**KIRKLEES METROPOLITAN COUNCIL
INVESTMENT & REGENERATION SERVICE**

**DELEGATED DECISION TO DETERMINE APPLICATIONS FOR
NON-MATERIAL AMENDMENTS**

Reference No:	2025/NM/93365/E
Site Address:	Cross Rink Street, Batley, WF17 6BH
Description:	Non material amendment to previous permission 2009/93382 for erection of retail development
Recommending Officer:	Katie Chew

| DATE: 21.10.25<br>SCALE: 1:100<br>SIZE: A1   | DRAWN: AHD<br>CHECKED: ANK<br>DRG NO: 24.2782.05 |

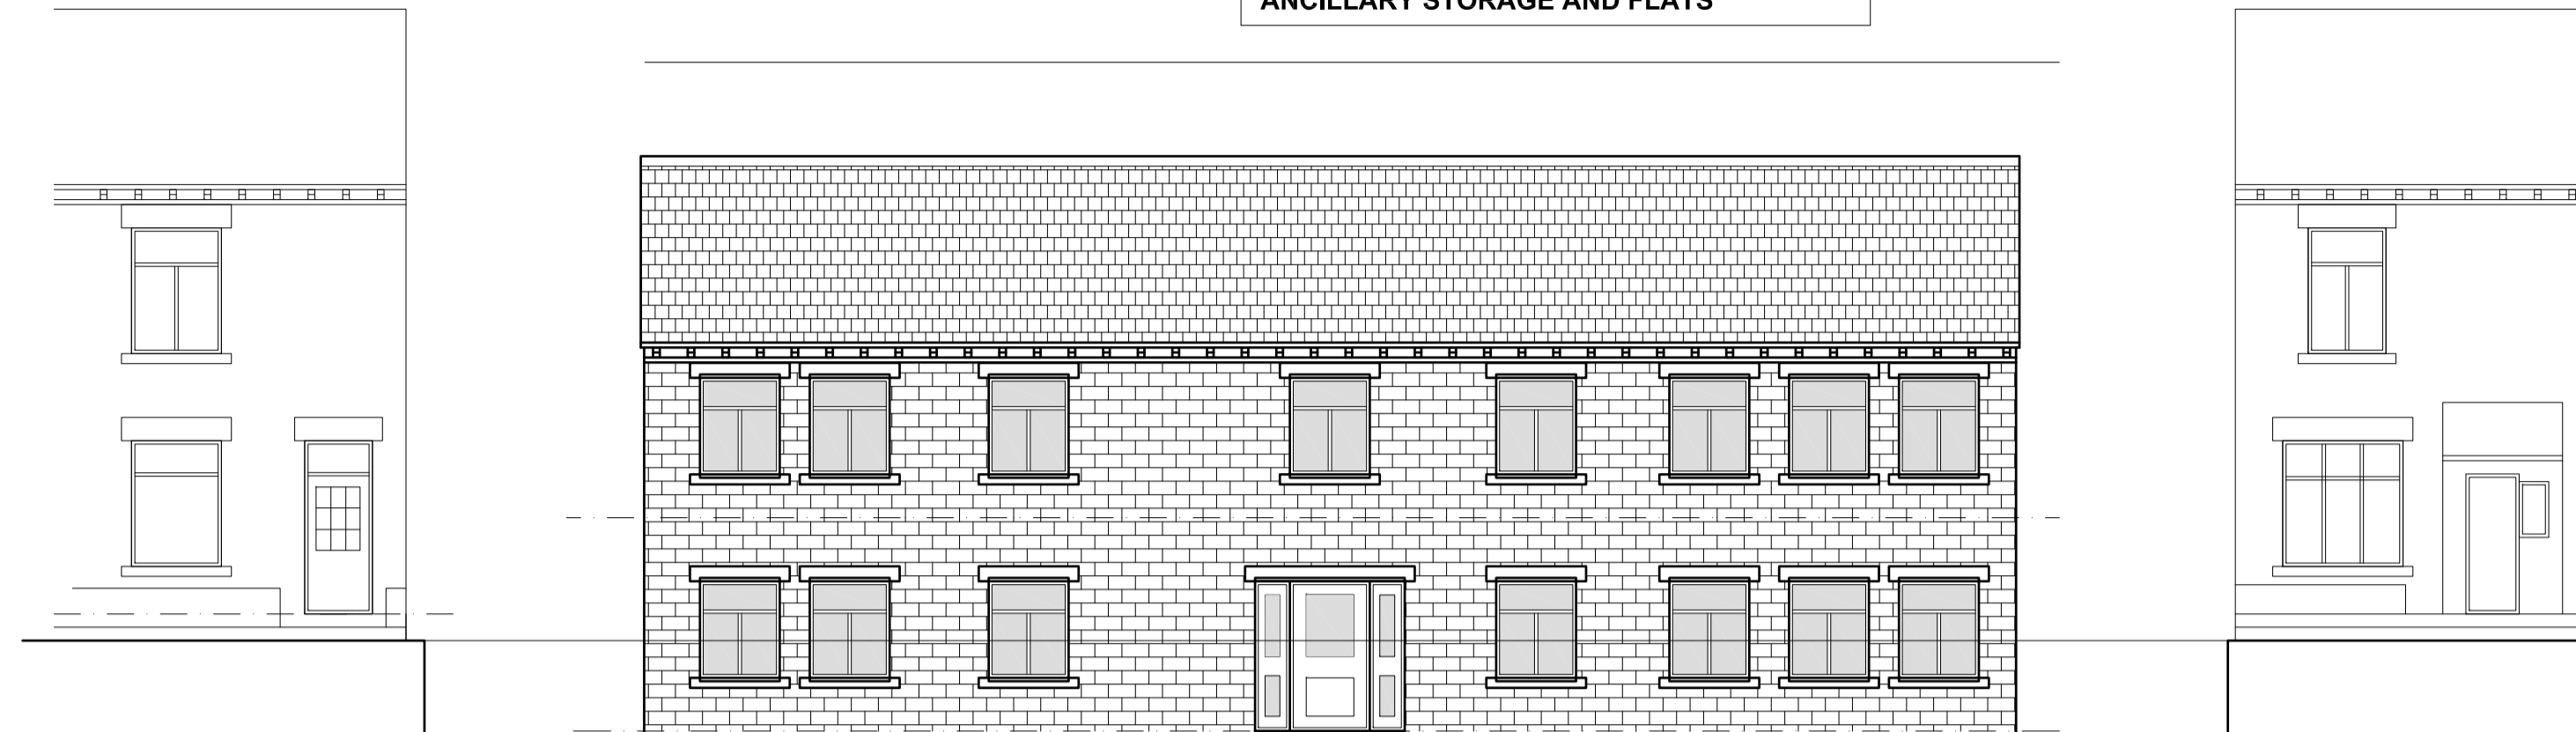
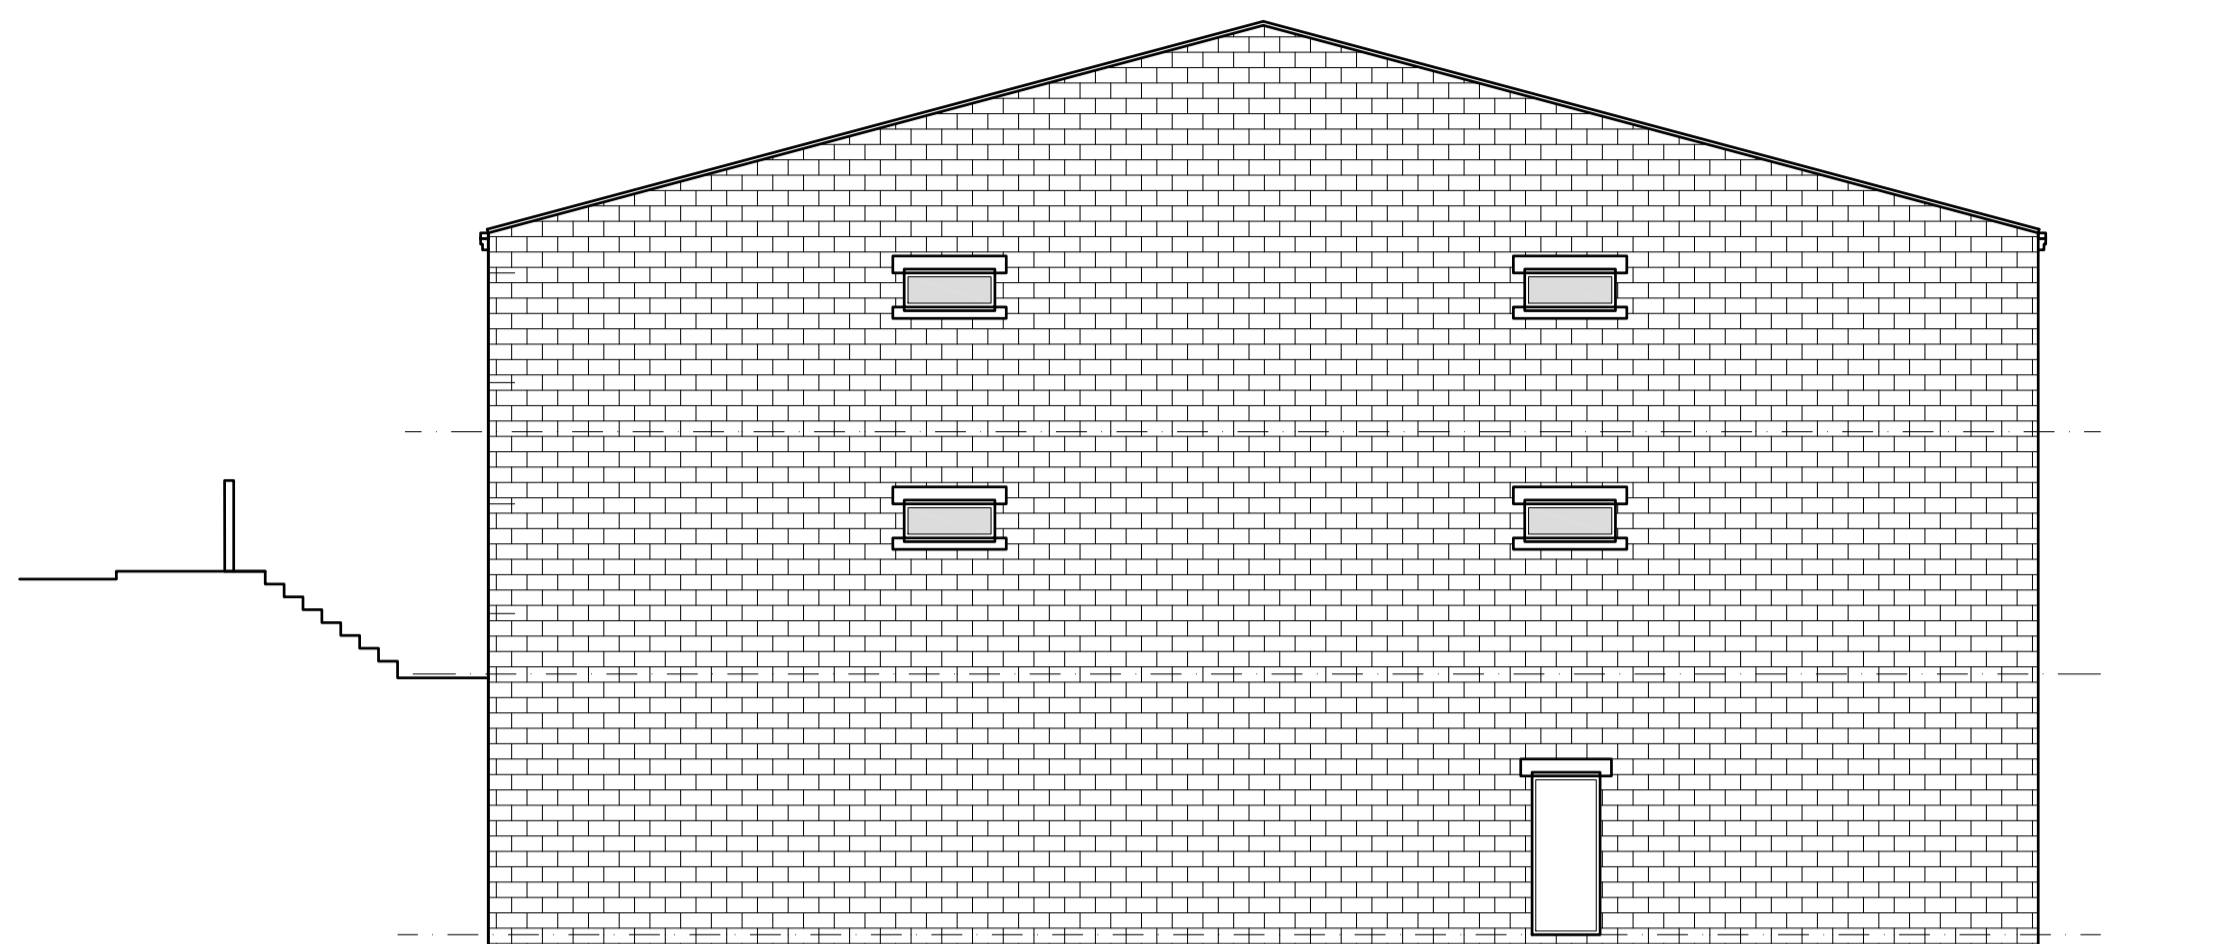
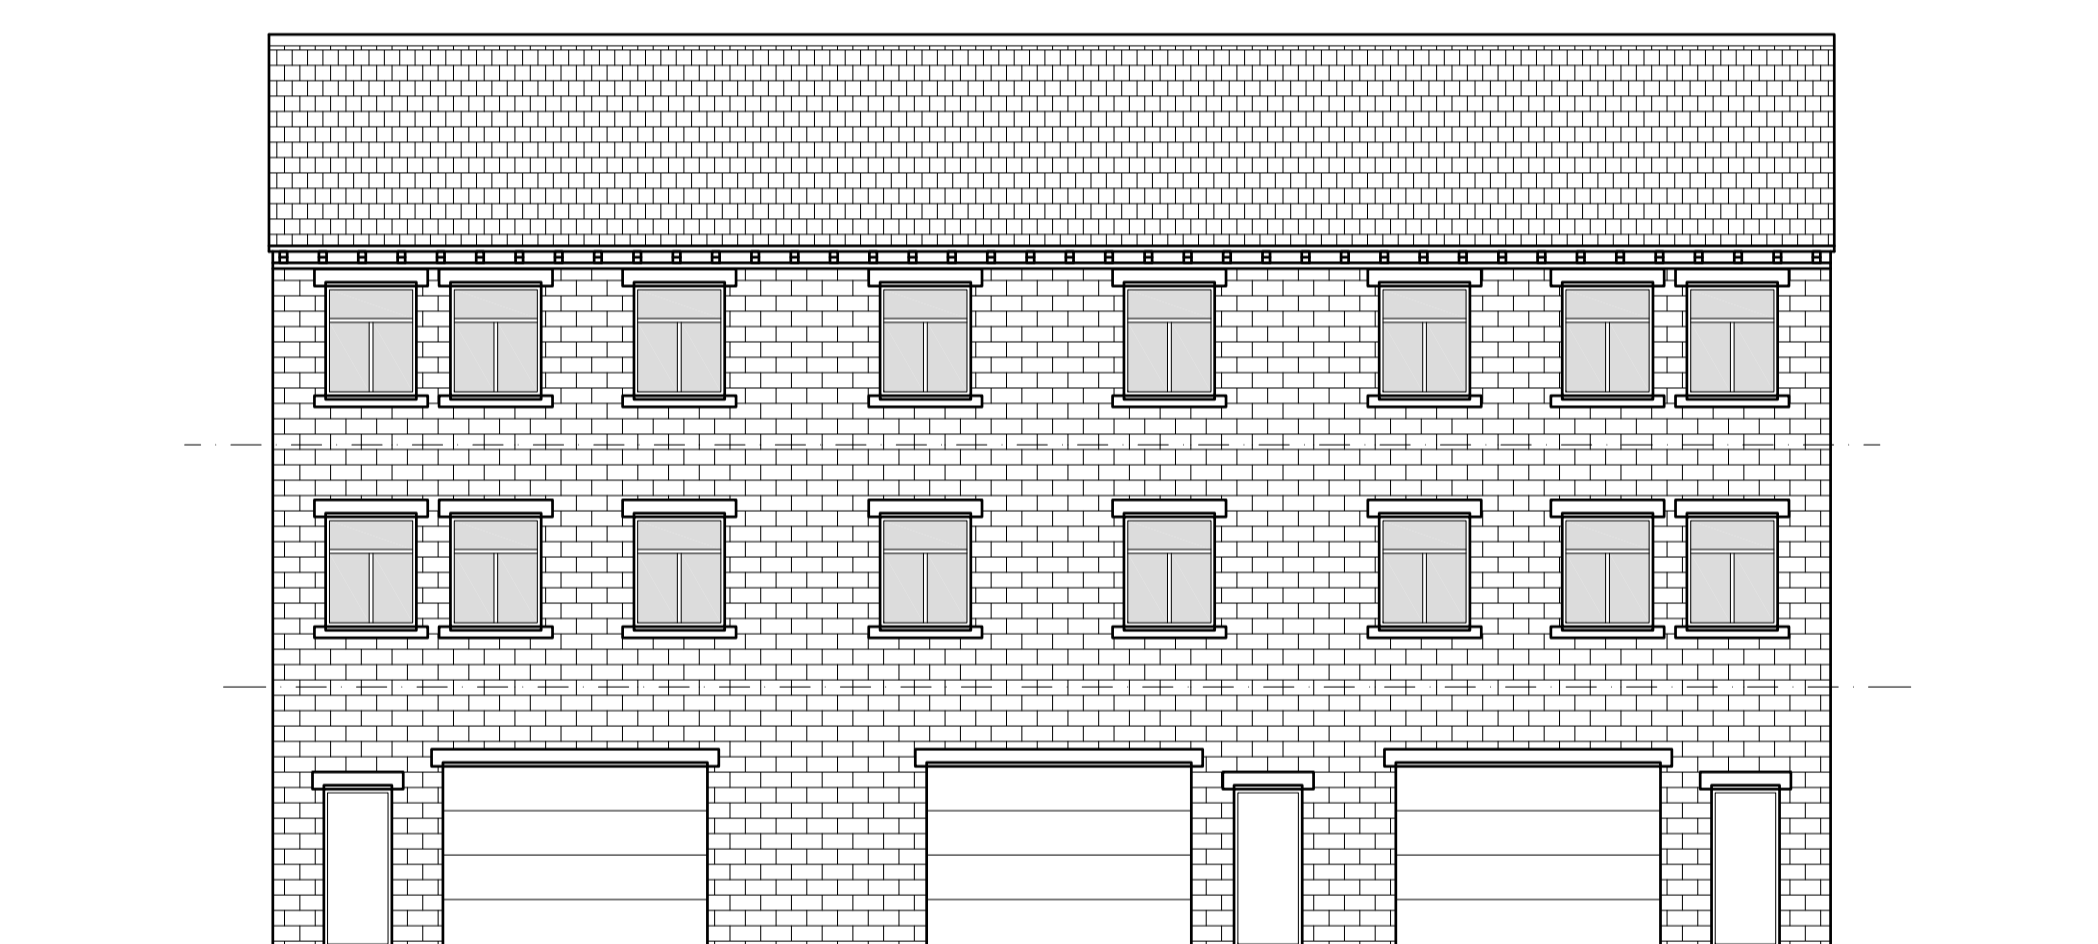
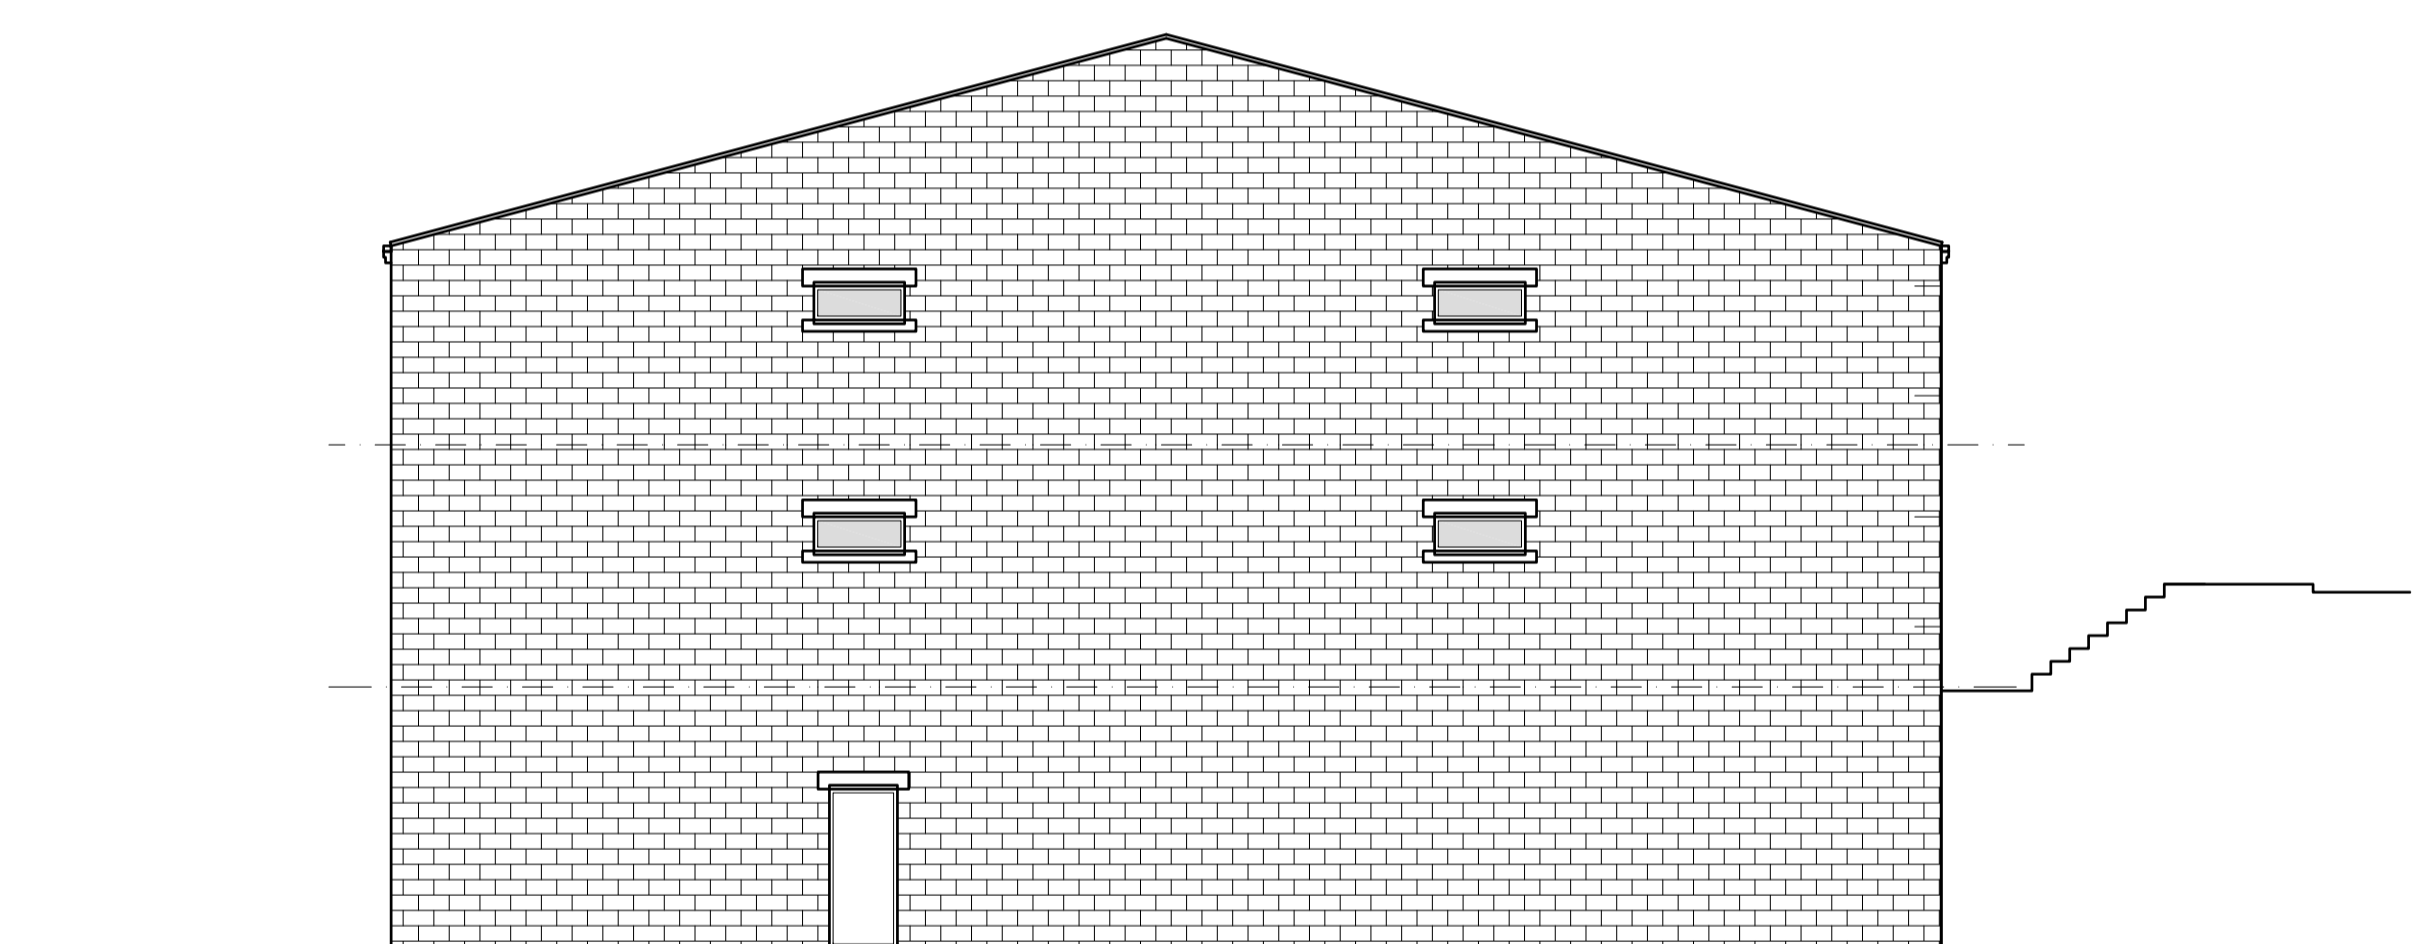
Amendments have been sought to the originally approved structure to increase its height by around 0.7m. Changes have also been made throughout the external elevations in terms of the design, window and door arrangements. No details have been provided in respect of materials and therefore Officers cannot confirm whether these are to be as approved, or not. The access and parking arrangements appear to have also changed, with a smaller, gated entrance shown on the submitted block plan, than previously approved. Parking numbers have changed with an increase of 2 spaces, due to the loss of 2 originally approved disabled spaces. Finally, the overall use of the site is proposed to be changed from a retail unit with storage and staff facilities, to 10 flats and warehouse storage.

Given the increase in height, altered arrangement of windows and doors, lack of detail in terms of materials used, and a change to the parking layout and use overall of the site, Officers cannot give a view on these matters at this time. A full assessment would need to be undertaken under a full planning application to ascertain whether the proposals would result in a detrimental impact either visually or in terms of living conditions.

YES. The proposals seek to increase the size of the building by 0.7m.

- Amendments to the originally approved structure to increase its height by around 0.7m.
- Changes made throughout the external elevations in terms of the design, window and door arrangements.
